Please ask for: Kathryn Welch
Email: kathryn.welch@arun.gov.uk
Telephone: 01903 737789
Our Ref: BE/19/21/T
Your Ref:
Date: 26th February 2021

Application for Works to Trees(s) subject to a Tree Preservation Order(TPO)

Development: Various Works to various trees within retail park.
Location: Arun Retail Park Shripney Road Bognor Regis PO22 9NF

Q161-01 Tree Survey Plan

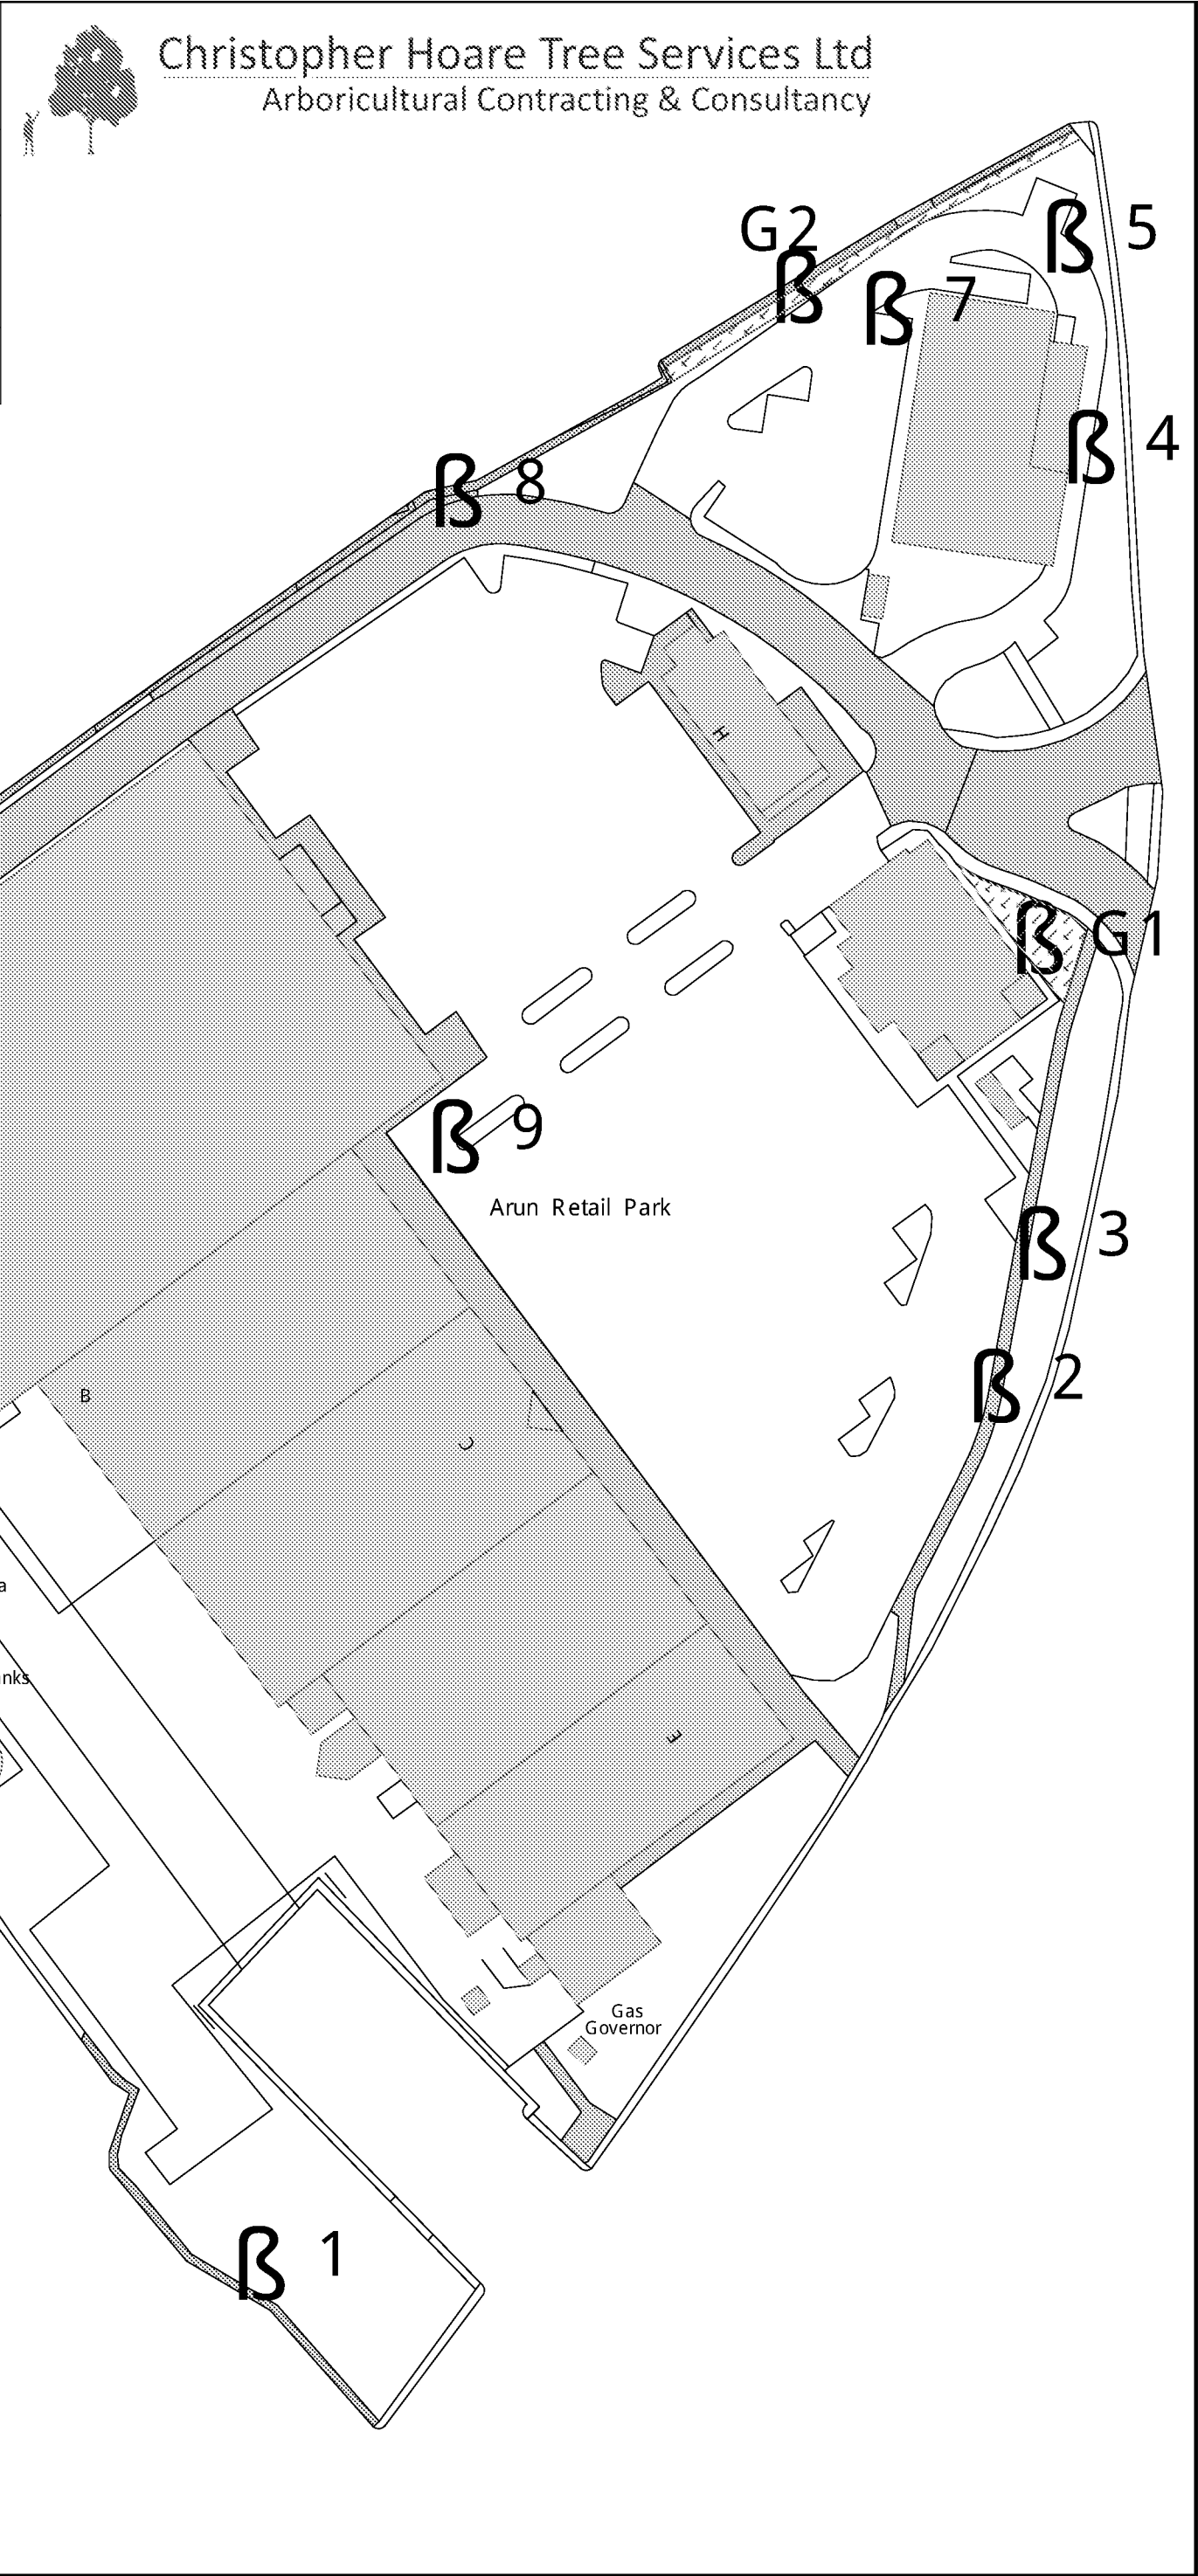
Please provide details of replacement tree in lieu of tree 3.

Please provide proposed spread measurements (m) for trees/groups;

-G1 & G2

-1 & 7

Where the works are not radial then please also provide details as to which direction (NSEW) works will be undertaken.
